Comment from Greenspace

Further to submission of Landscape Strategy plan dwg 2518-0101 we advise that this shows just an indicative proposal and further detail would need to be submitted in plan form than shown. Landscape detail to include species choice, actual quantities, planting densities and size at time of planting. The proposals would need to be suitable for situation having a varied and appropriate mix with a good palate of both evergreen and deciduous trees and shrubs. The proposed scheme would need to be sufficient in height to provide instant impact whilst an appropriate size to aid establishment.

APPLICATION NO: AL/33/19/RES

Description of Works: Approval of reserved matters following the consent of AL/8/16/OUT (APP/C3810/W/16/3155330) for the erection of 14 No. dwellings with associated access, parking, landscape & open space.

DRAWING
Landscape Strategy Plan

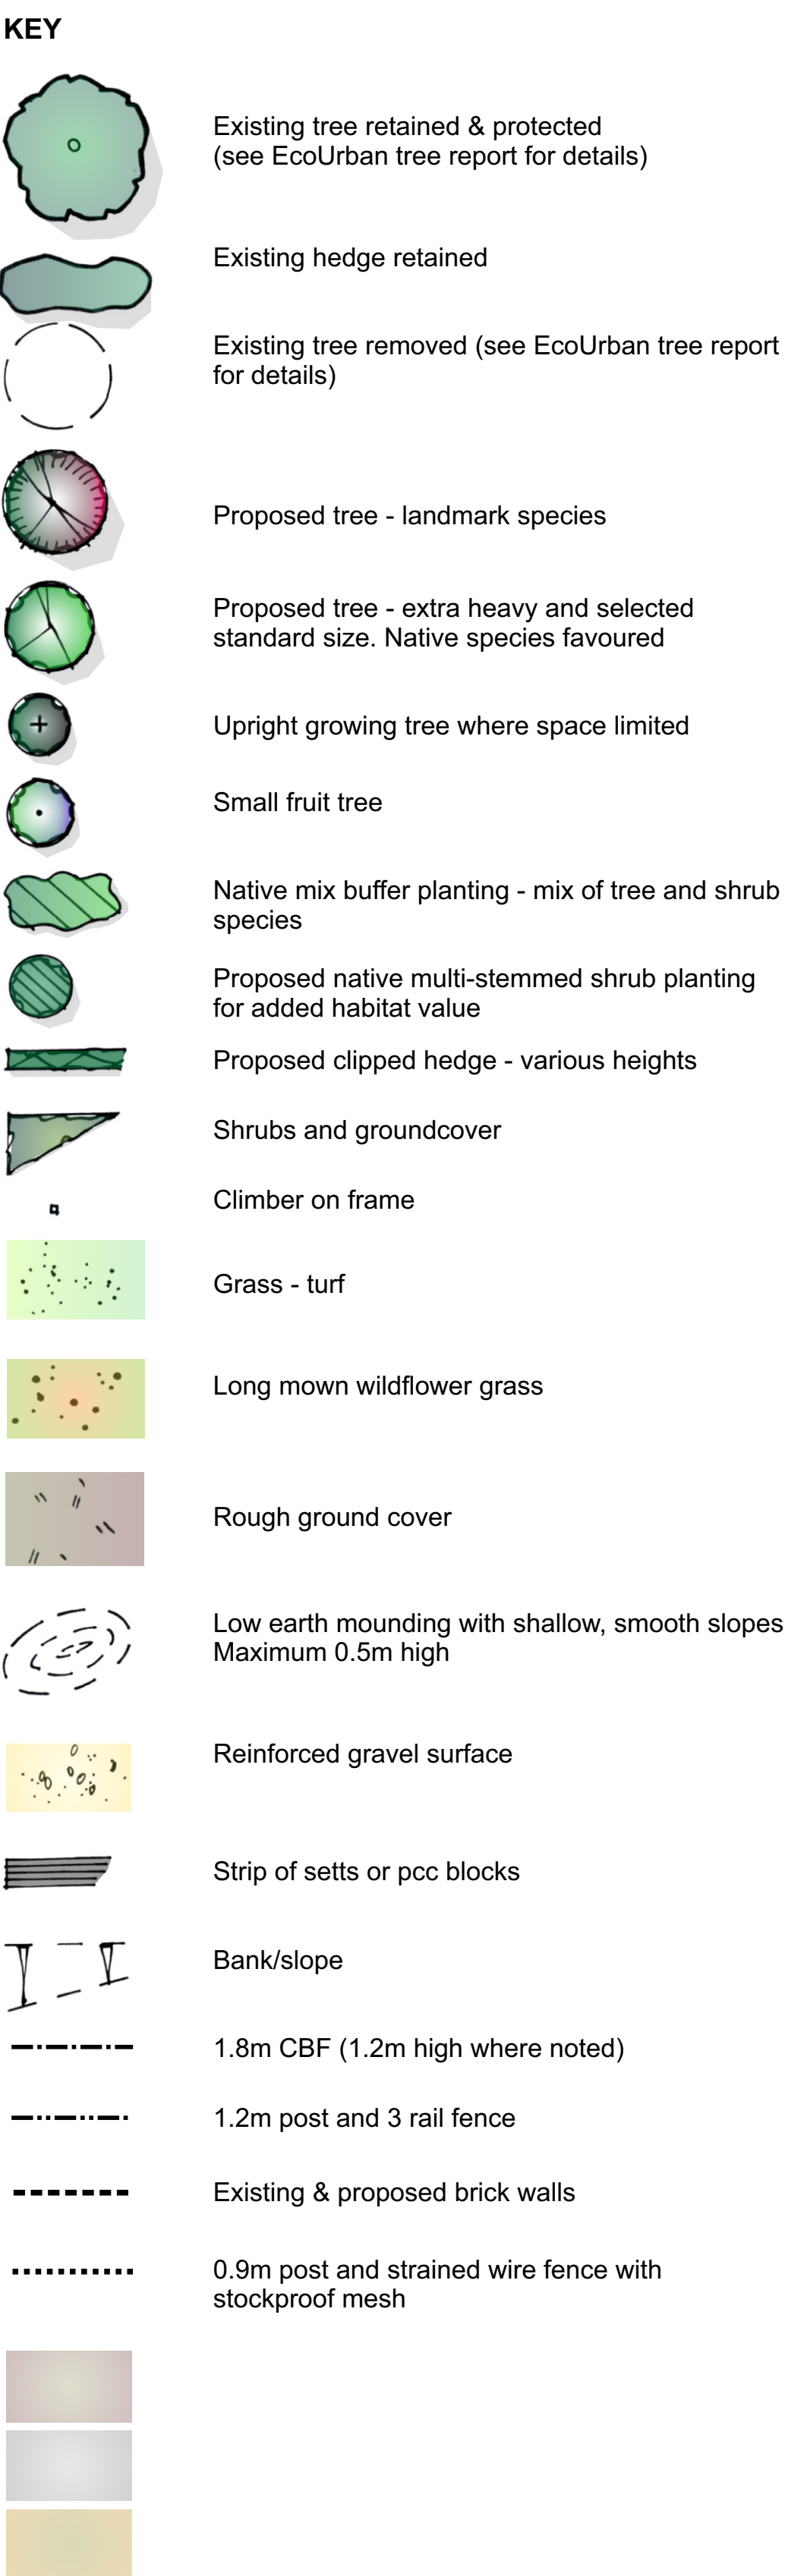
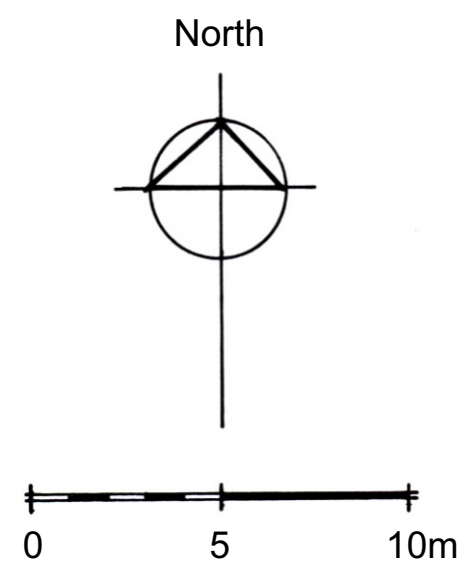
The drainage requirements of the site would need to be concluded and any effect this may have on the proposed open space indicated. Quantities of POS should not be compromised by any change to drainage provision.
